[REDACTED] email below from the applicant regarding the change to the **justification** for the proposed alternative access onto Tye Lane set out in planning application **WA/63/21/PL**.

Subject: Alternative Access Tye Lane Walburton WA/63/21/PL

A1 Scale	Date	Designed by
1:500	DEC 2020	KI
Drawn by	Checked by	Approved by
KI	KI	KM
Drawing Number	183248-003	
Rev	C

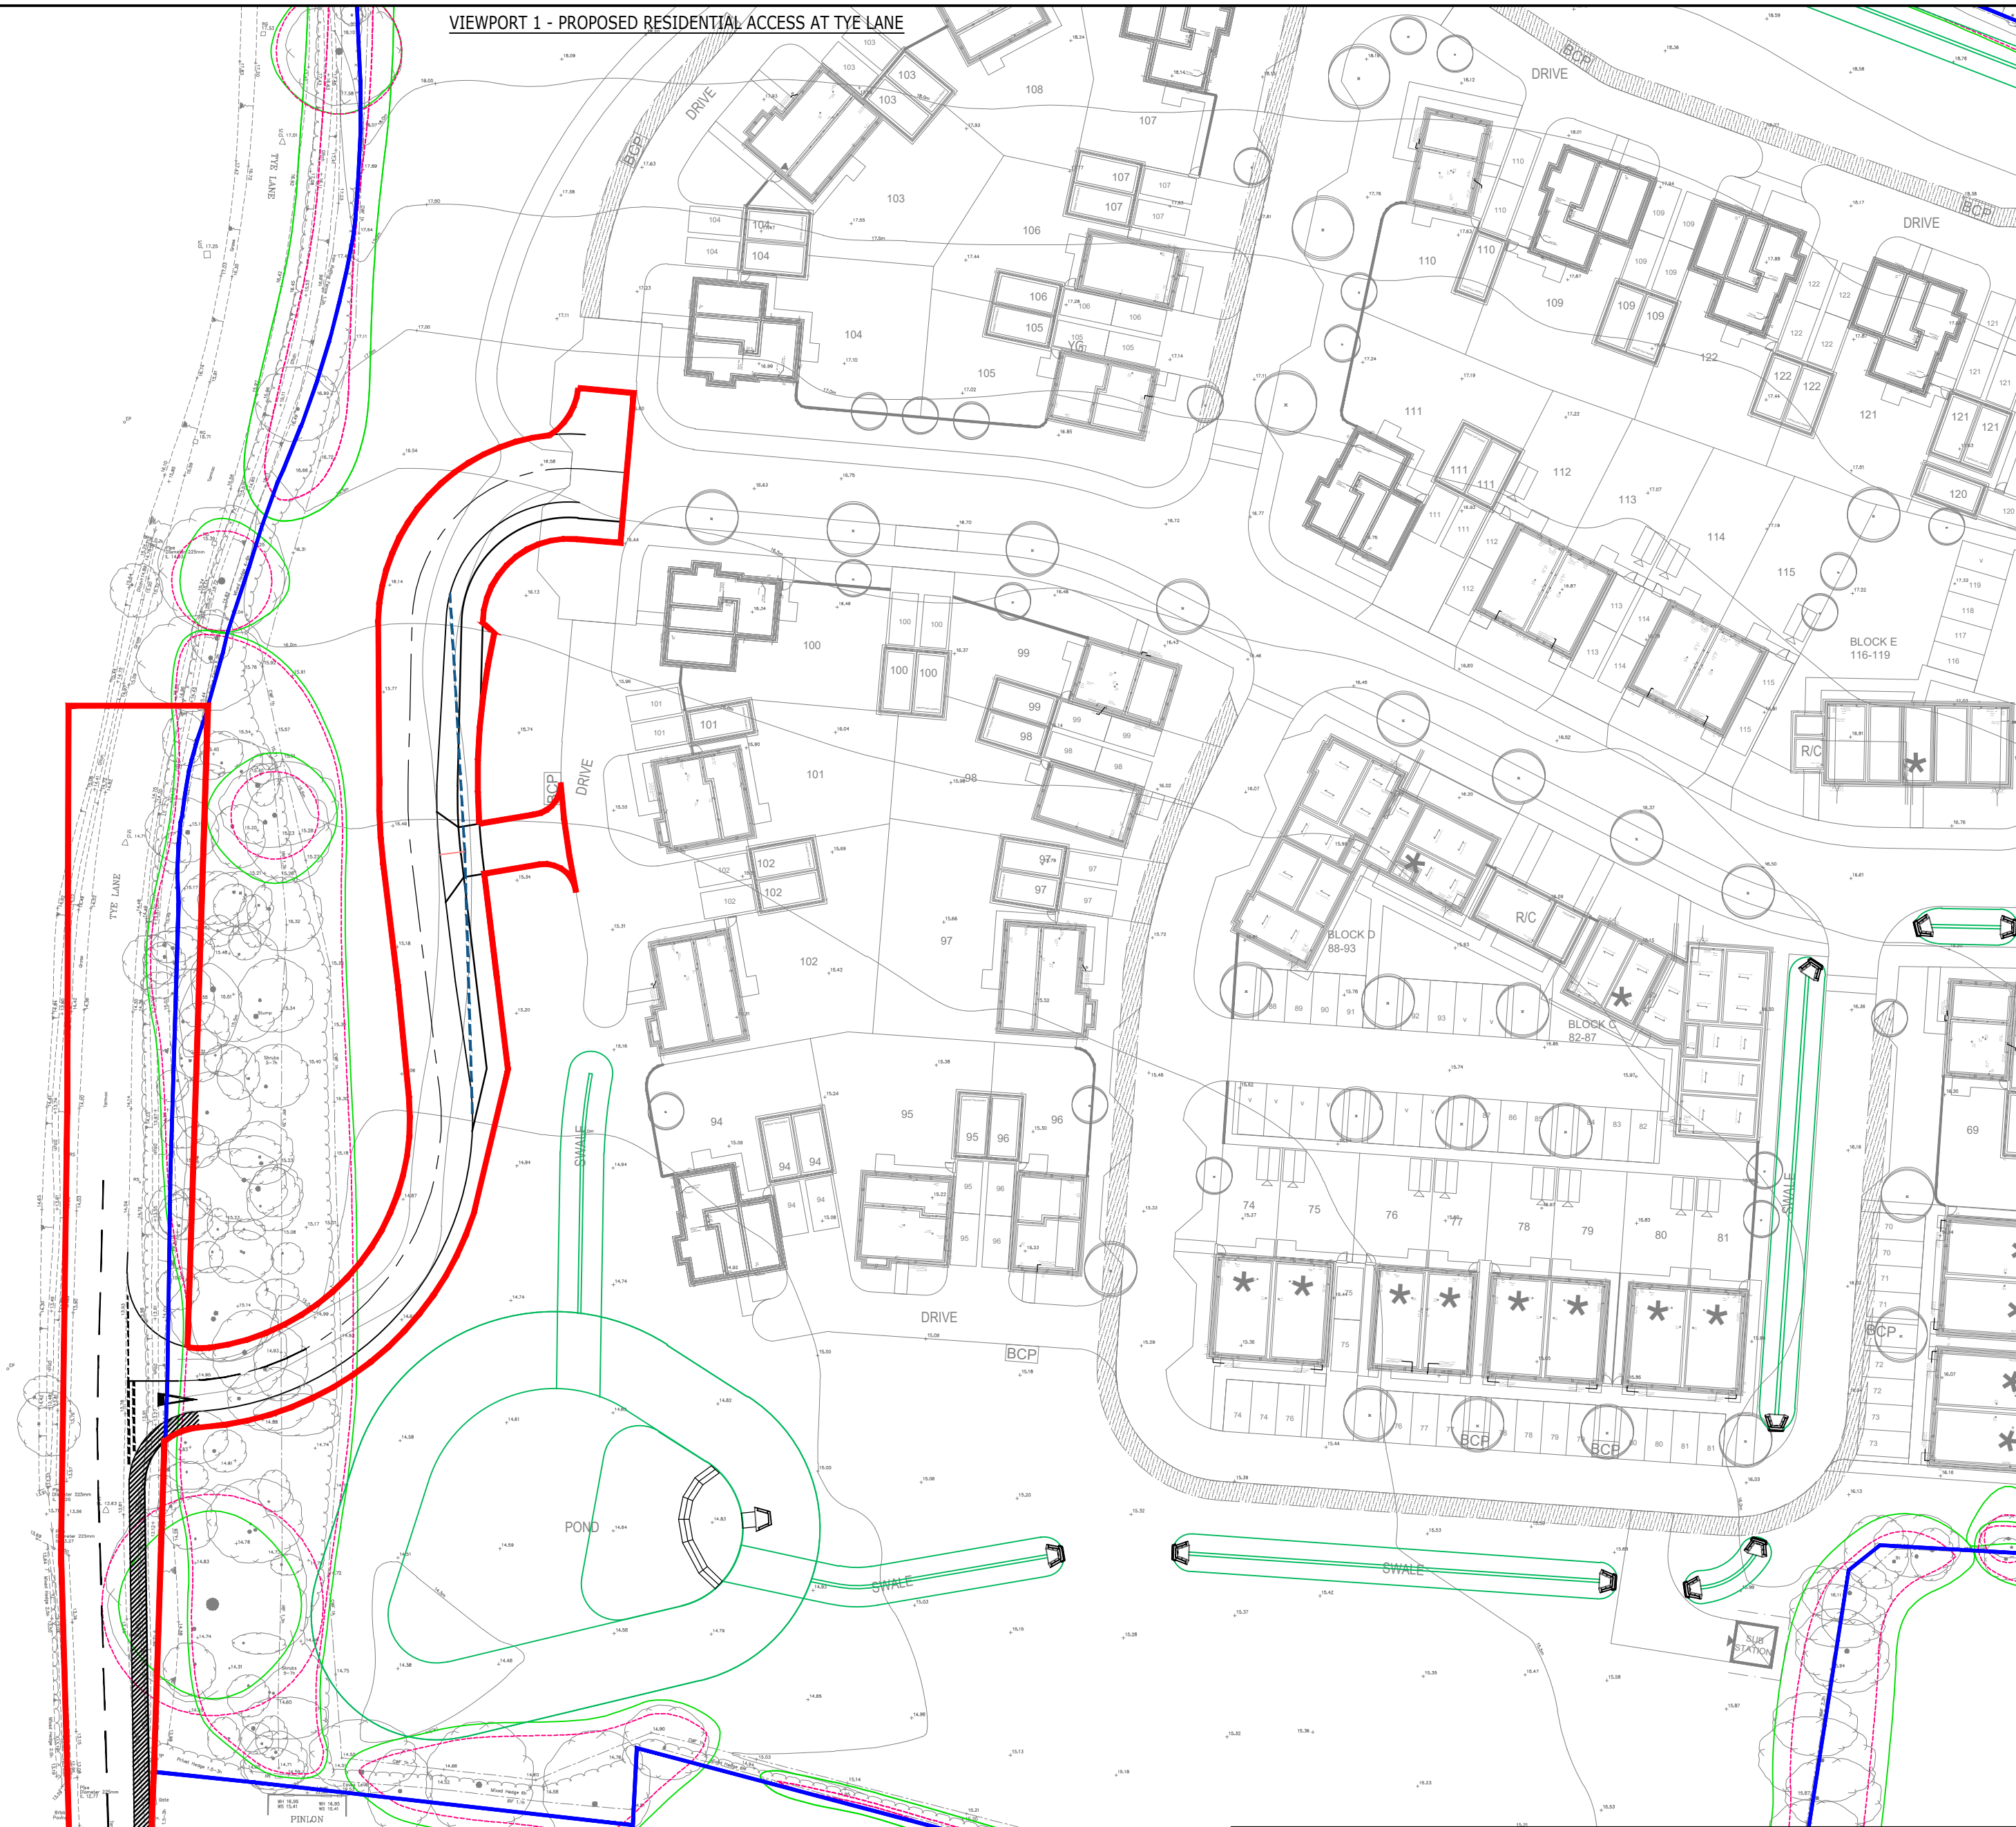
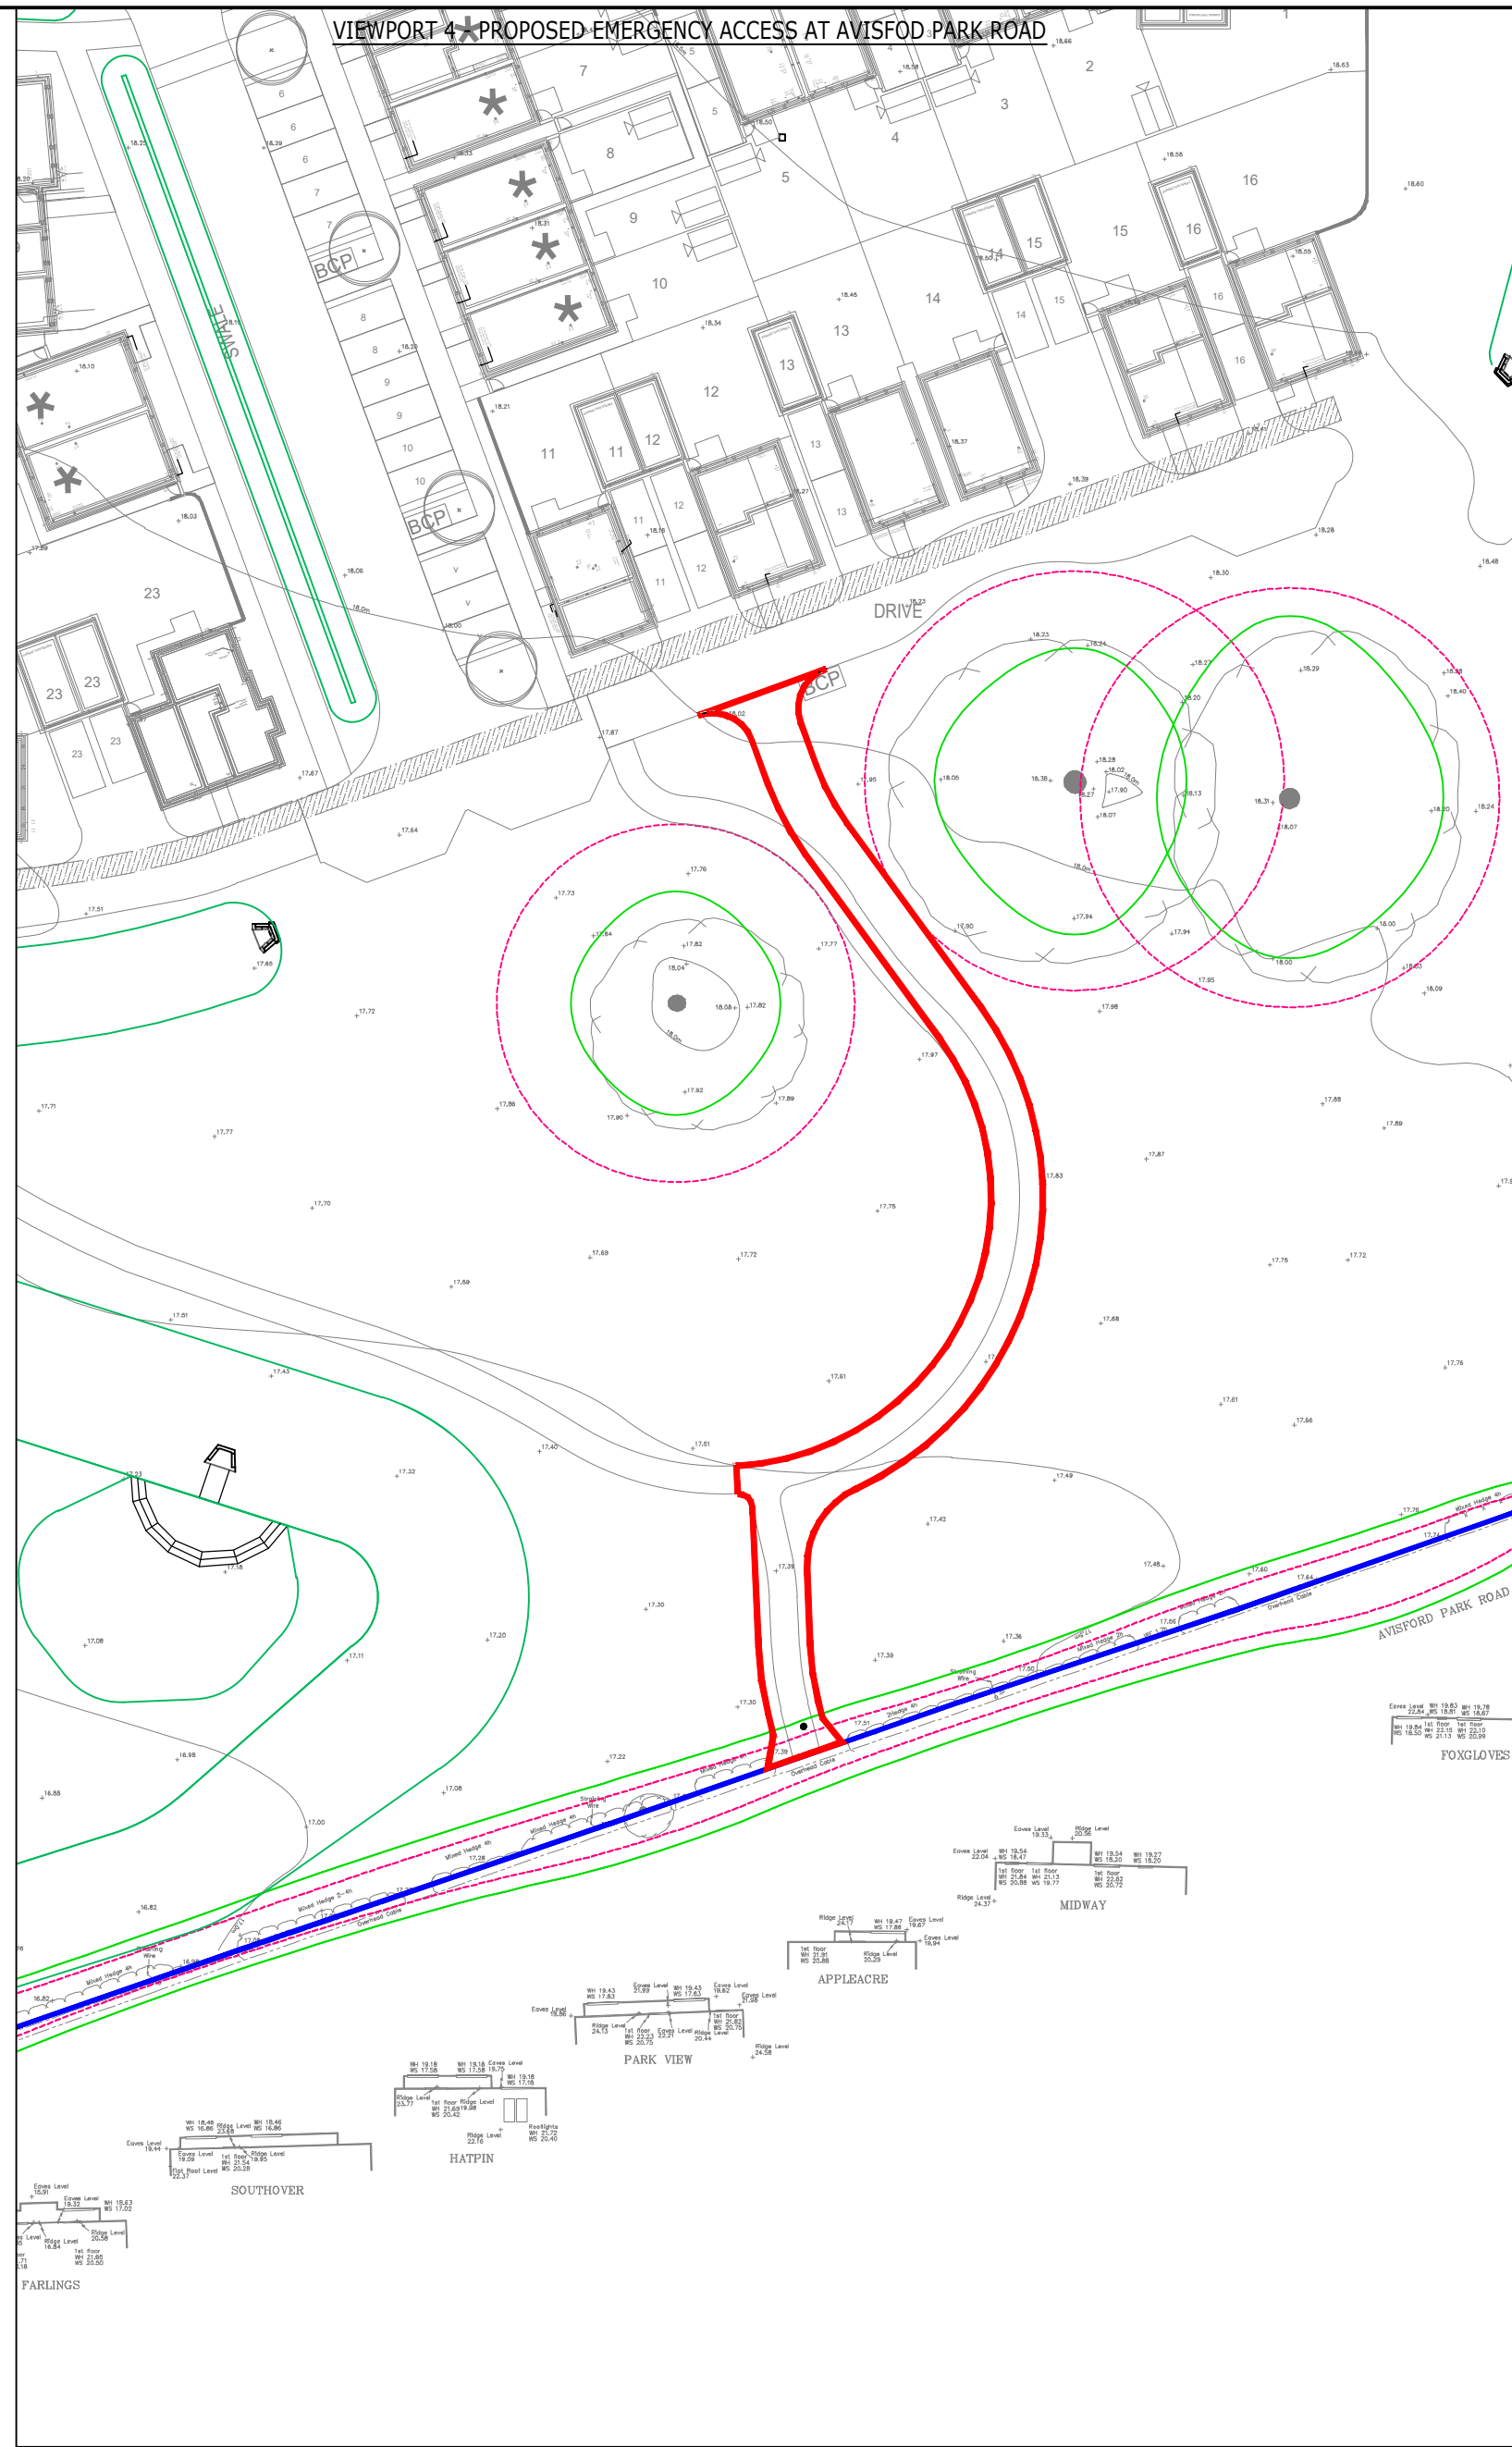
- *Comment 1 (Culvert invert level vs the foul pipe invert level):* As the foul pipe is part of the proposed works we have the ability to lower the foul pipe invert to provide greater clearance to the culvert. Given the downstream connection invert, we would be able to lower the proposed foul pipe by over one metre.

- *Comment 2 (Ability to deepen the watercourse given the constraints that exist):* Pending further investigation to determine the presence of tree roots, the supplied drawing demonstrates that from a levels perspective, the proposed culvert and ditch realignment can be achieved.

- *Comment 3a (The proposed cross-sections are narrower than existing, leading to a loss of capacity):* The proposed ditch bed width is 0.5m, this is only 88mm narrower than the existing bed width at the upstream end of the proposed works. Any loss of capacity is more than compensated for by the proposed deepening of the ditch and the resulting increase in cross-sectional area. This is evident in the table below which compares the existing and proposed cross-sectional areas in all three sections shown on drawing 183248-001:

- *Comment 3b (Steep side slopes will lead to erosion and collapse):* The long term stability of the ditch will be considered during detailed design. If necessary for erosion protection, we would opt to use a proprietary slope stabilisation product which allows vegetation growth. One such solution is EnkaMat which has been used with great success on previous projects and promotes strong vegetation growth for permanent erosion protection.
- *Comment 3c (Works within the tree root protection areas):* [Insert advice from CSA]. If the further investigative works reveal the presence of significant tree roots within the area of the realigned ditch, we would recommend a lengthening of the culvert to avoid damage to the tree roots. This option would entail significantly less excavation.

Cross-section (ref. drawing 183248-001)	Existing Cross-sectional Area (m2)	Proposed Cross-sectional Area (m2)	Proposed % Increase in Cross-sectional Area
A-A	0.93	1.17	25.8%
B-B	1.25	1.85	48.0%
C-C	0.91	1.06	16.4%

- In respect of the ditch excavations works and the close presence of the TPO trees, we would recommend that exploratory air spade works are carried-out along the length of the ditch, under the supervision of the appointed arboriculturalist, particularly to the south of the proposed access to establish if any major roots are present within the extent of the proposed excavation.

- Once air spade exploratory works are complete, the extent of potential impacts can be thoroughly evaluated and any amends to the ditch proposals made accordingly or where root pruning is the only viable option, an approach agreed in partnership with the LPA tree officer and set-out in a detailed Arboricultural Method Statement.

- Once the final scheme is agreed, works to form the new ditch should continue to be undertaken through a combination of both air-spade works and hand-digging, all of which should be undertaken under the supervision of the appointed arboriculturalist.
